Rezoning Transportation Analysis

Petition Number: 2023-107

Date	Description
10-25-23	First Review (ME)
11-27-23	Second Review (ME)

# RZ-1.0

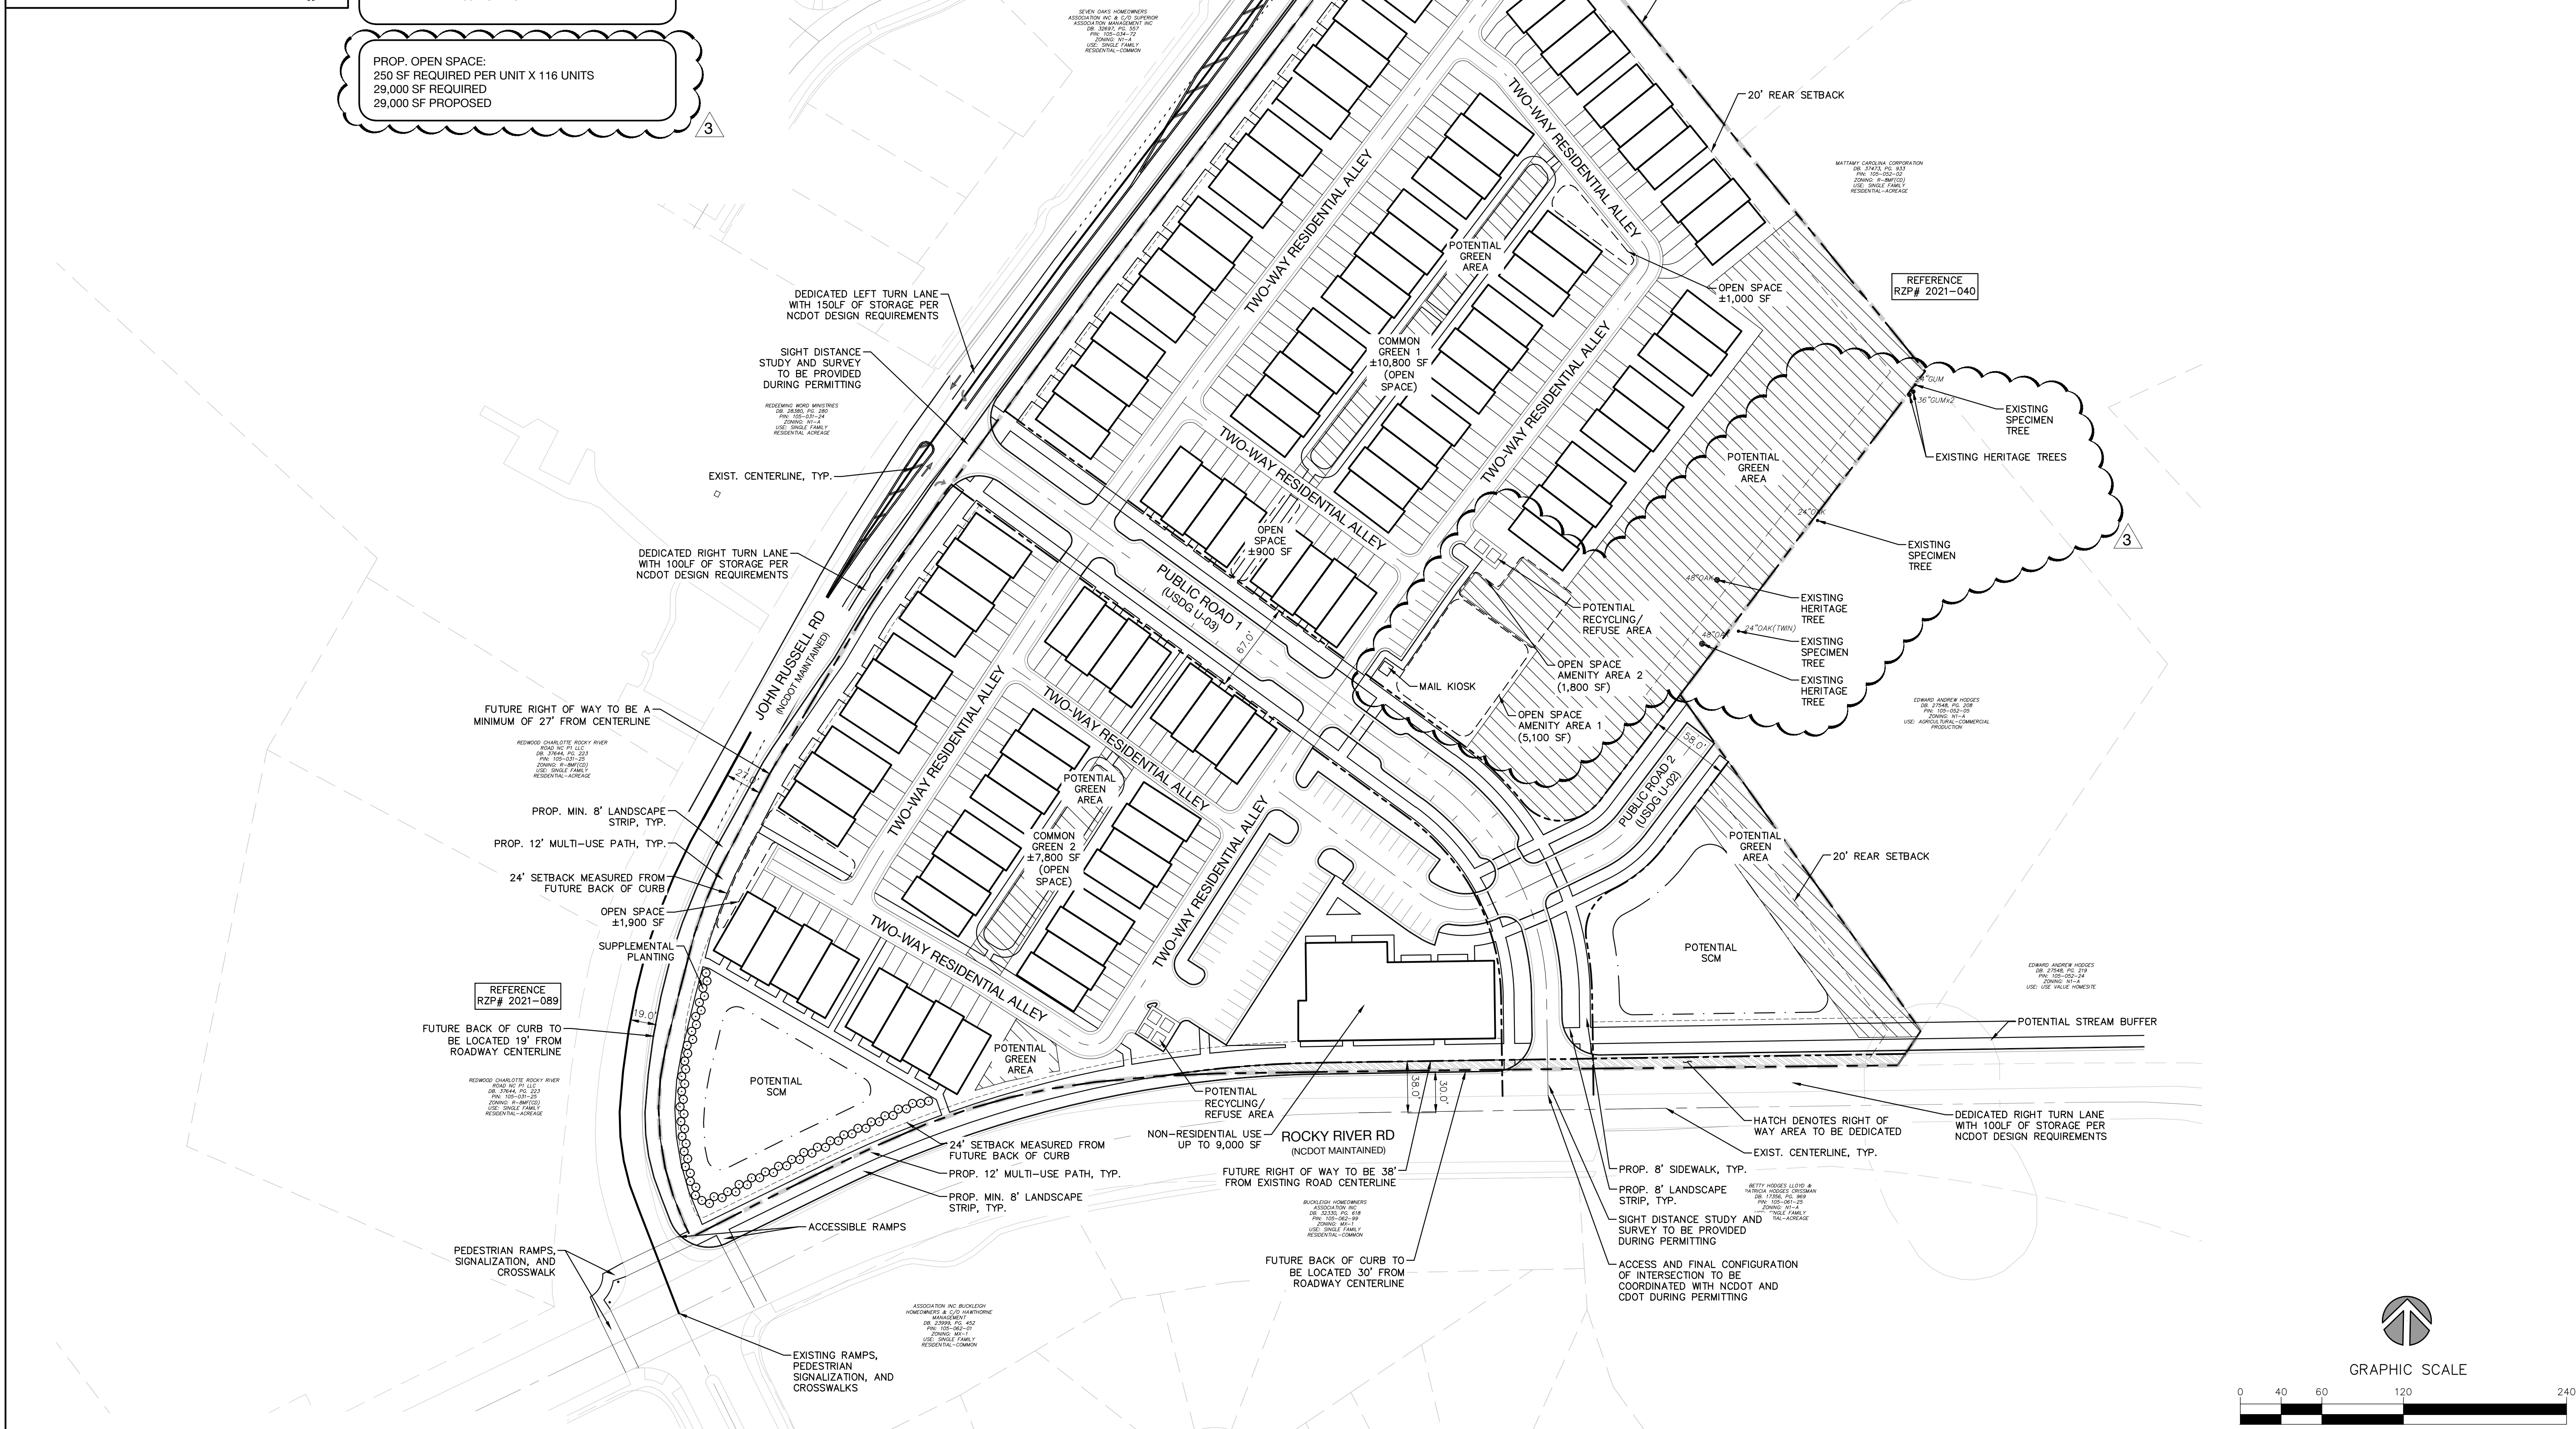
Label and dimension the curb and gutter from the centerline for each road on the site plan.

Reference (CLDSM standard detail 11.09) for both street typicals.

Comment 11-27-23: Please label and dimension the curb and gutter from the centerline for each road on the site plan.

3. Revise site plan and conditional note(s) to commit to dedicate 38 ft right-of-way from the road centerline for Rocky River Road and 27 ft for John Russell Road. The site plan shall label and dimension the right-of-way from the road centerline.

Comment 11-27-23: Please revise site plan to show correct dedicated right of way for each road with proper labeling and dimensioning.

7. Revise site plan and conditional note(s) to commit to installing ramps, crosswalks, and pedestrian signalization at intersection of Rocky River Road and John Russell Road in coordination with CDOT and NCDOT.

Comment 11-27-23: Please revise conditional note and site plan to show that this will be done for the entire intersection and not just the northeast corner of the intersection.

9. Revise site plan and conditional note(s) to commit to making the access right-in and right-out access only on Rocky River Road, constructing a dedicated right-turn lane into the site with 100-feet of storage and installing a 4 foot concrete monolithic island on Rocky River Road in coordination with NCDOT.

Comment 11-27-23: Please revise site plan and conditional notes to commit to the access and roadway improvements mentioned above from NCDOT. Please add labeling on site plan to reflect this access type.

10. Revise site plan and conditional note(s) to commit to making the access full movement on John Russell Road, constructing left and right turn lanes into the site on John Russell Road with 150-feet of storage and the appropriate tapers, and constructing a three-lane road section if proposed right turn and existing right turn lane taper onto Rocky River Road are within 100 feet of each other in coordination with NCDOT.

Comment 11-27-23: Please revise site plan and conditional notes to commit to the access and roadway improvements mentioned above from NCDOT. Please add labeling on site plan to reflect this access type.
